Online Comment

Application H02-1028-23
Location 75 SOUTH STREET CROWLAND PETERBOROUGH PE6 0AH
Proposal First Floor Rear Extension

Name Greg Watkinson
Address Conservation Officer

title PROPOSED ELEVATIONS	scale 1:100 @ A3	date NOVEMBER 2023
contract MR STEVE HUTSON	revision A 17/11/2023 DRAWING FIRST ISSUED B 20/11/2023 WINDOW REVISED

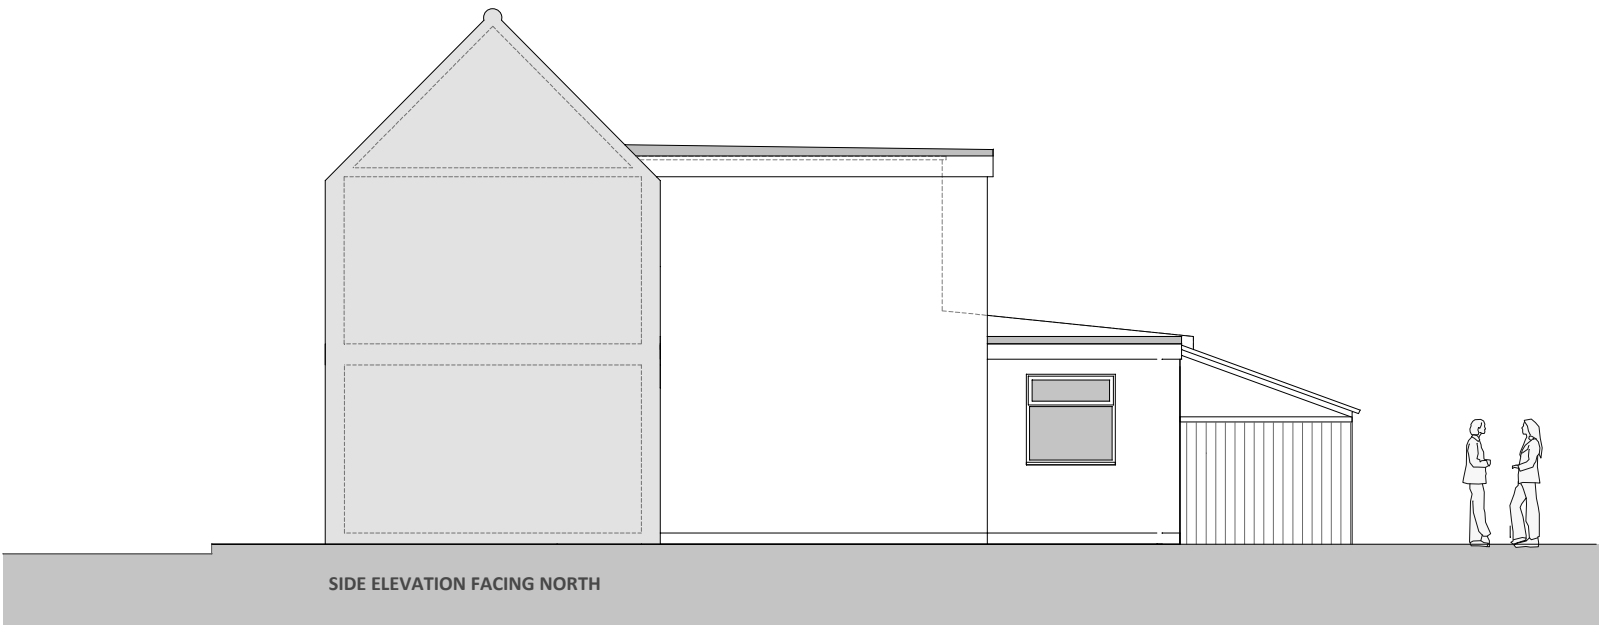
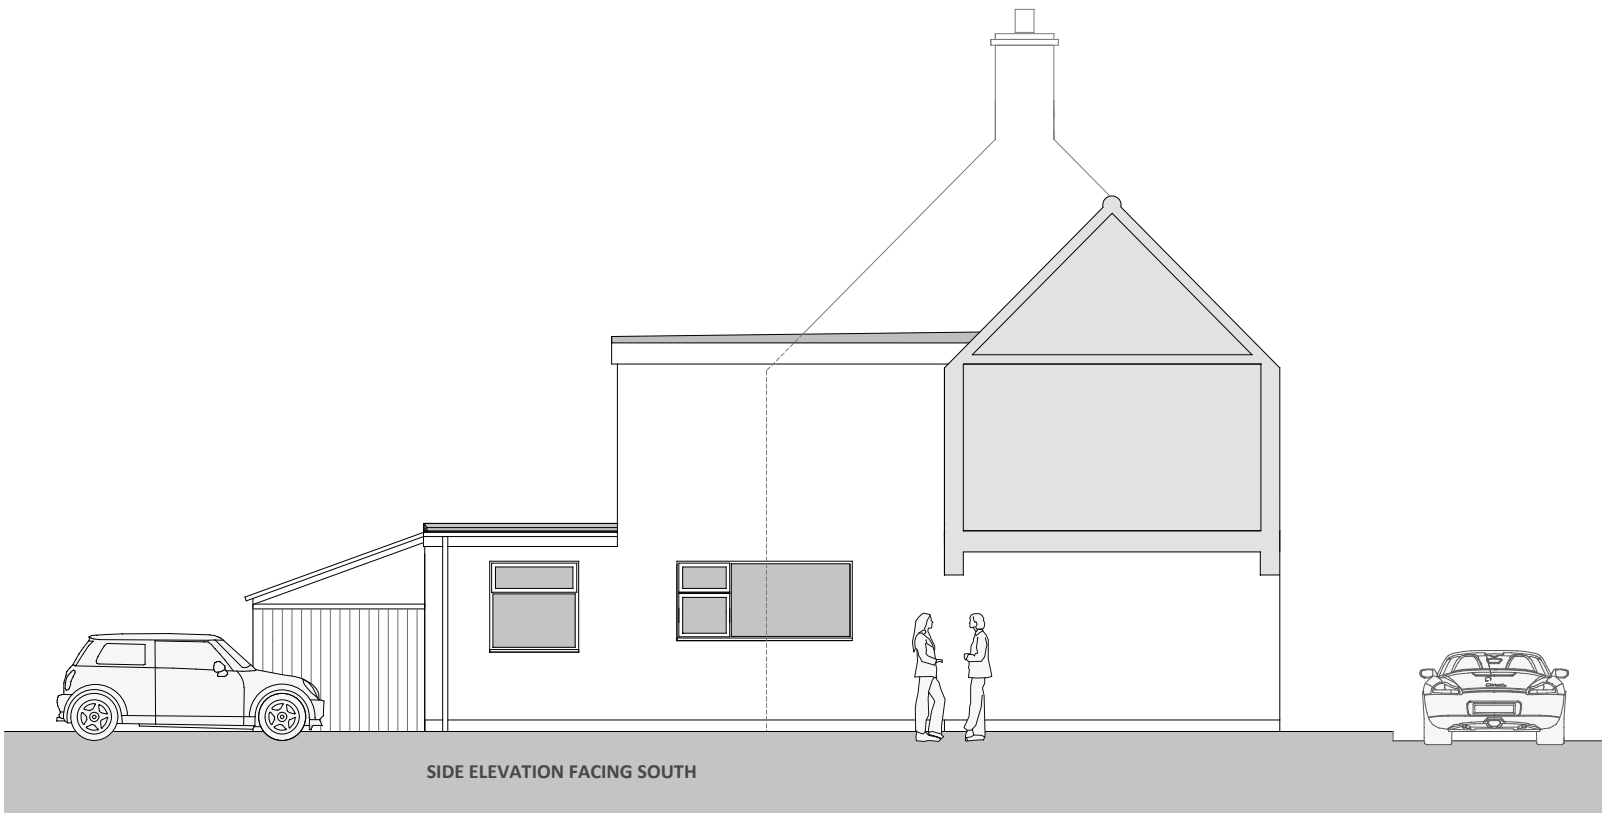
I write to confirm that I have no objections to this proposal. Whilst the proposal does utilise design and materials (such as UPVC) which are not of a particularly high quality that would typically befit a conservation area setting, this rear extension would be totally shielded from public realm views both into and out of the conservation area. As such, on the balance of probabilities, I conclude that such a proposal would not have a material negative impact upon the public appreciation of the designated heritage asset.
